Our ref: NA/2020/115279/07-L01
Your ref: A1 in Morpeth
Date: 04 June 2021

**A1 IN NORTHUMBERLAND: MORPETH TO ELLINGHAM: EXAMINER
WRITTEN QUESTIONS (EXQ4)**

**A1 IN Northumberland: Morpeth to Ellingham Development Consent Order
Application Planning Inspectorate Reference: TR010059**

**The Examining Authority's written questions and requests for information
(ExQ4) Issued on 24 May 2021**

Permanent Works at the River Coquet

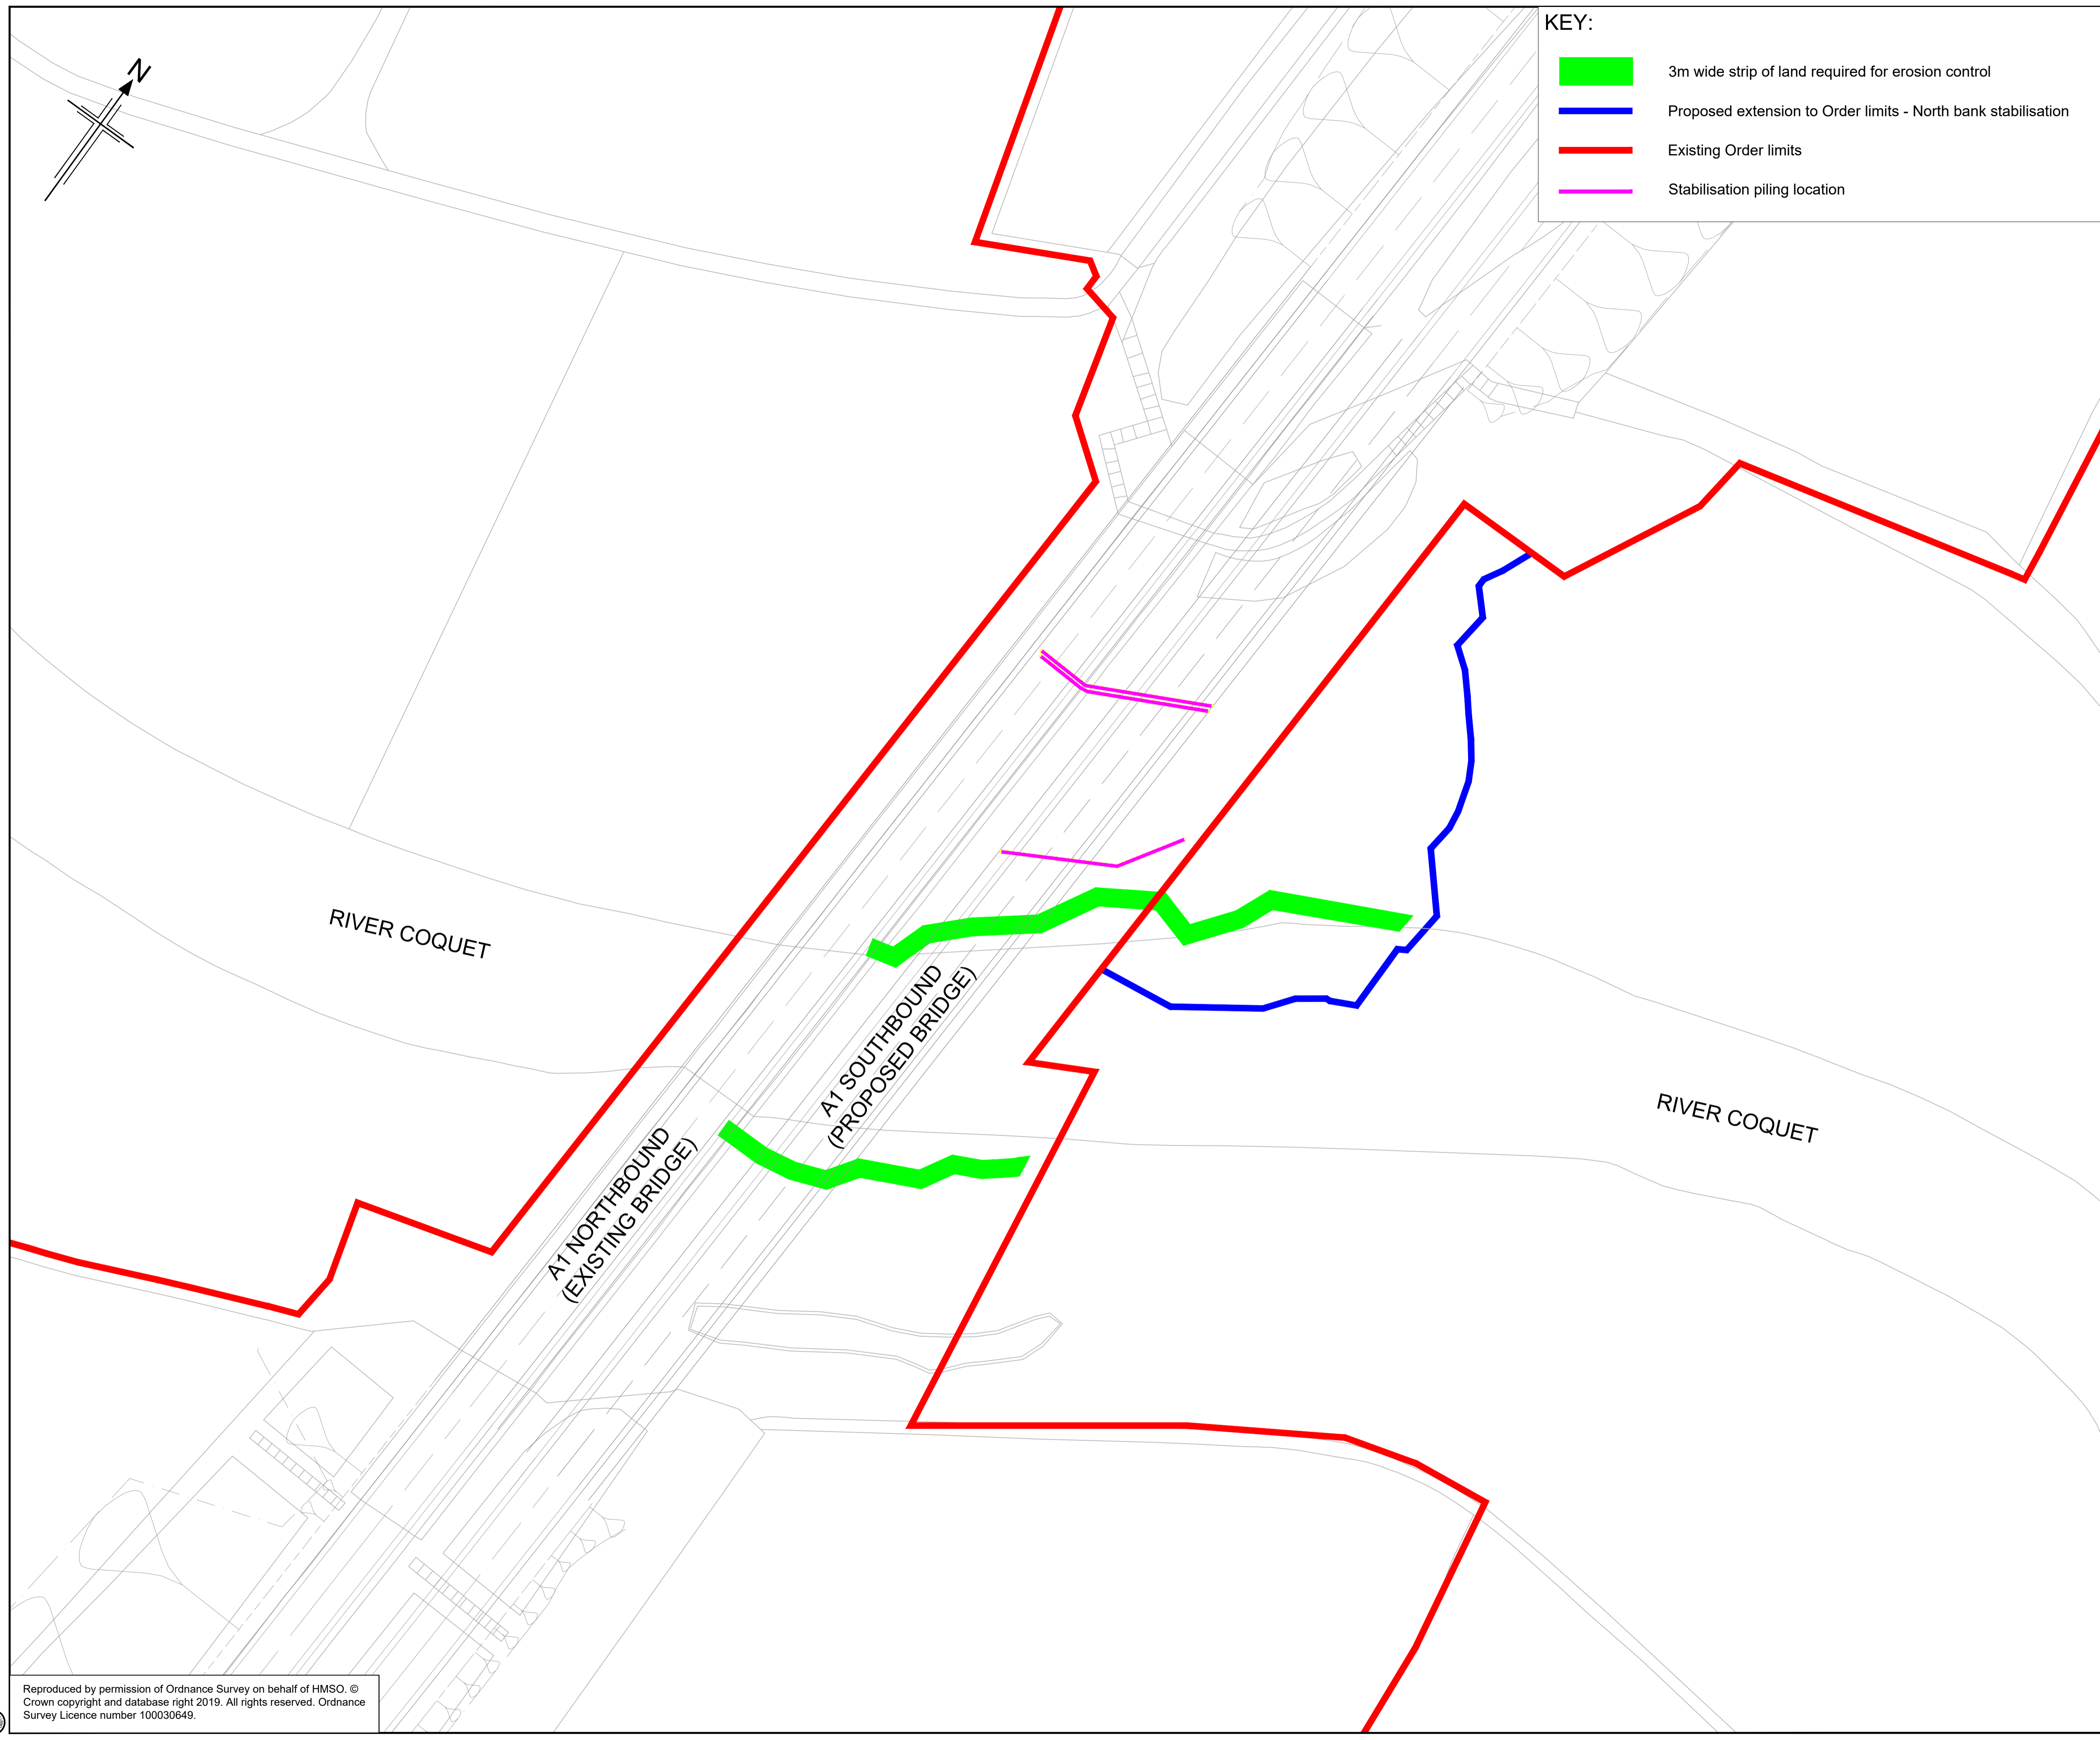
WE.4. 2	EA NE	<p>The EA [REP5-044] and NE [REP5a-004] have expressed concerns regarding the effect of the change request for stabilisation work and southern access works on to the River Coquet,</p>

<p>particularly in relation to its geomorphology. Consequently, the EA has requested that the River Coquet Geomorphology Modelling Assessment be updated. The Applicant has submitted the River Coquet Fluvial Geomorphology Assessment [REP07-003] in order to address these concerns.</p> <p>Can the EA and NE please confirm if they are satisfied with the information submitted and if there are any remaining concerns in relation to the effects of the change request for stabilisation work and southern access works on the River Coquet?</p>
		<p>EA response: We are satisfied with updated geomorphology assessment. We have no outstanding concerns in relation to the effects of the stabilisation and southern access works. However, we disagree with the Applicant's determination of the nature and scale of the impact. The Applicant has stated that the scheme will have a 'minor adverse' impact. We consider the impacts to be 'moderate adverse' as the Applicant is permanently fixing the channel in this location, thus preventing the river from changing and adapting. Overall, we consider the impacts to be 'moderate adverse' and that the Applicant must provide compensation for the impacts of the stabilisation and southern access works. The Applicant is prepared to make a contribution towards offsite works in order to compensate for the stabilisation and southern access works and for the localised loss of watercourses. This would be subject to a legal agreement. The details of the contribution and associated offsite works are currently under discussion with the Applicant.</p>
